**MP\_09\_0153: Dr Chau Chak Wing Building – section 75W application**

Further to our conversation on 20 February, please find attached our Section 75W application for a request to modify a major project.

SPRINKLER
TANK RL
UPDATED

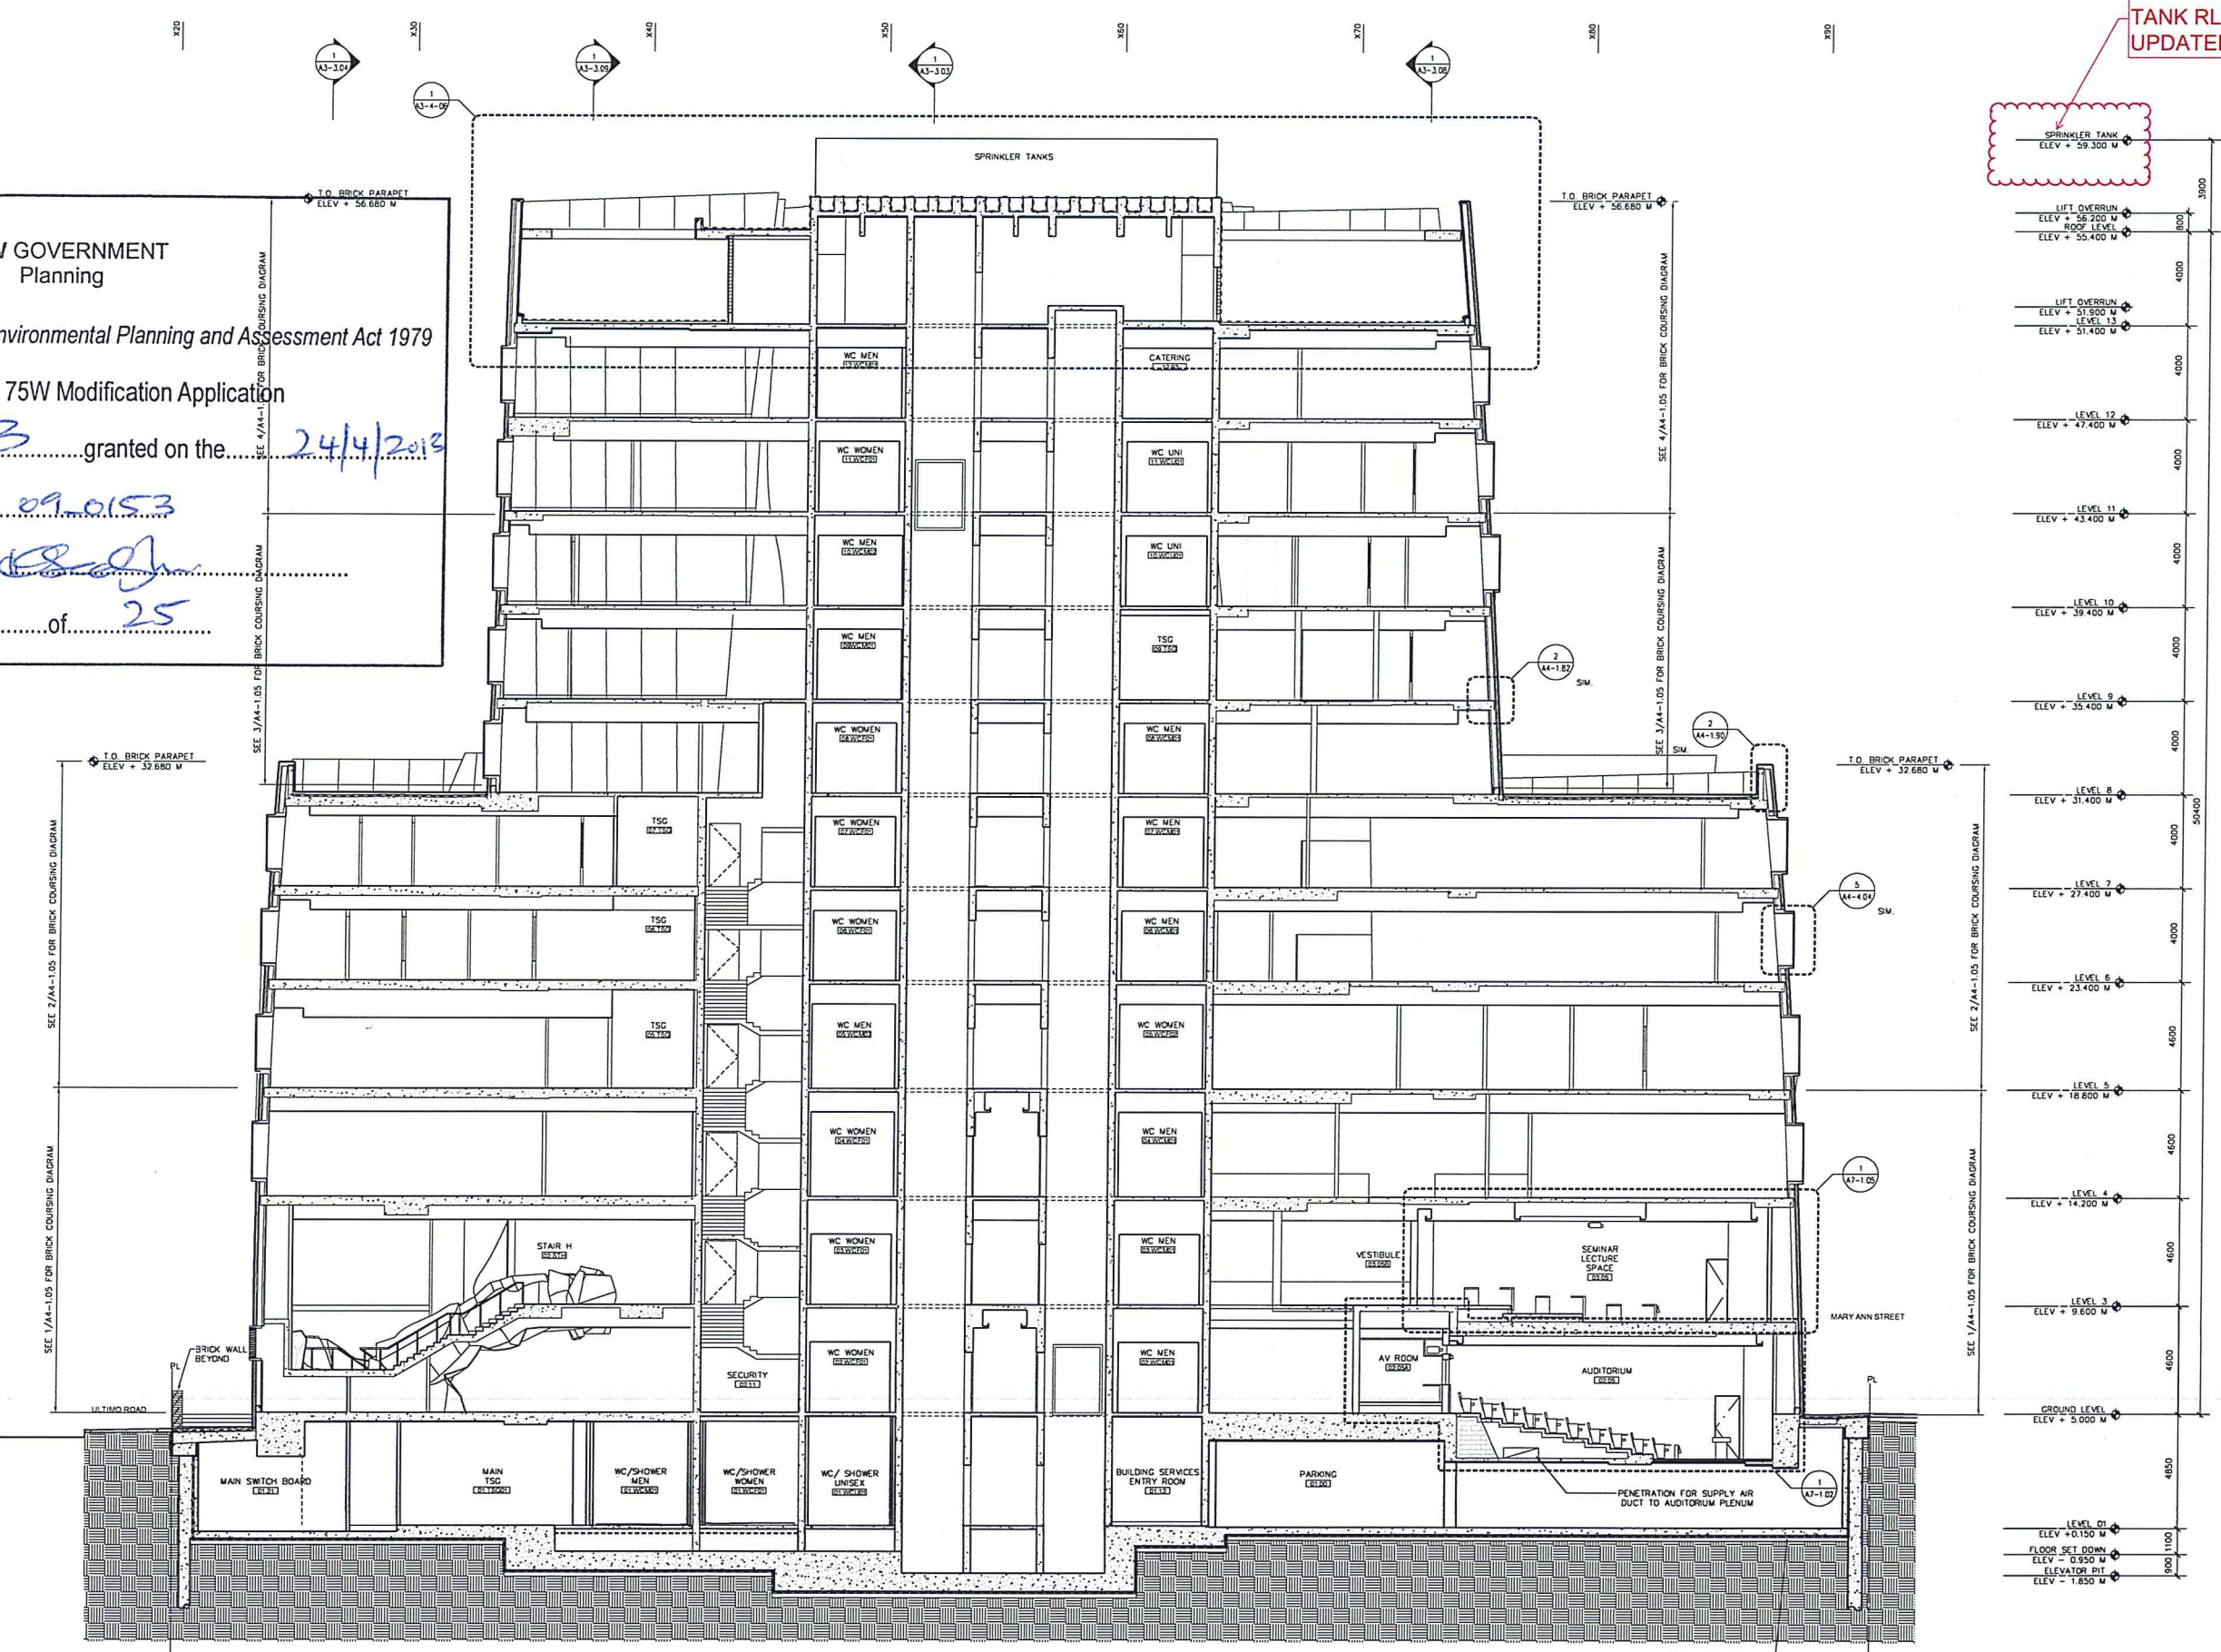
The alternate mechanical design solution following a Value Engineering process is the replacement of cooling tower and triggen plant with air cooled chillers. The plant room roof plan has been changed to reflect the new mechanical system in place. This modification was pursued as the triggen system proposed for the existing scheme was too small to extract maximum efficiency from the technology and was considered more sustainable to connect to a city wide system when available.
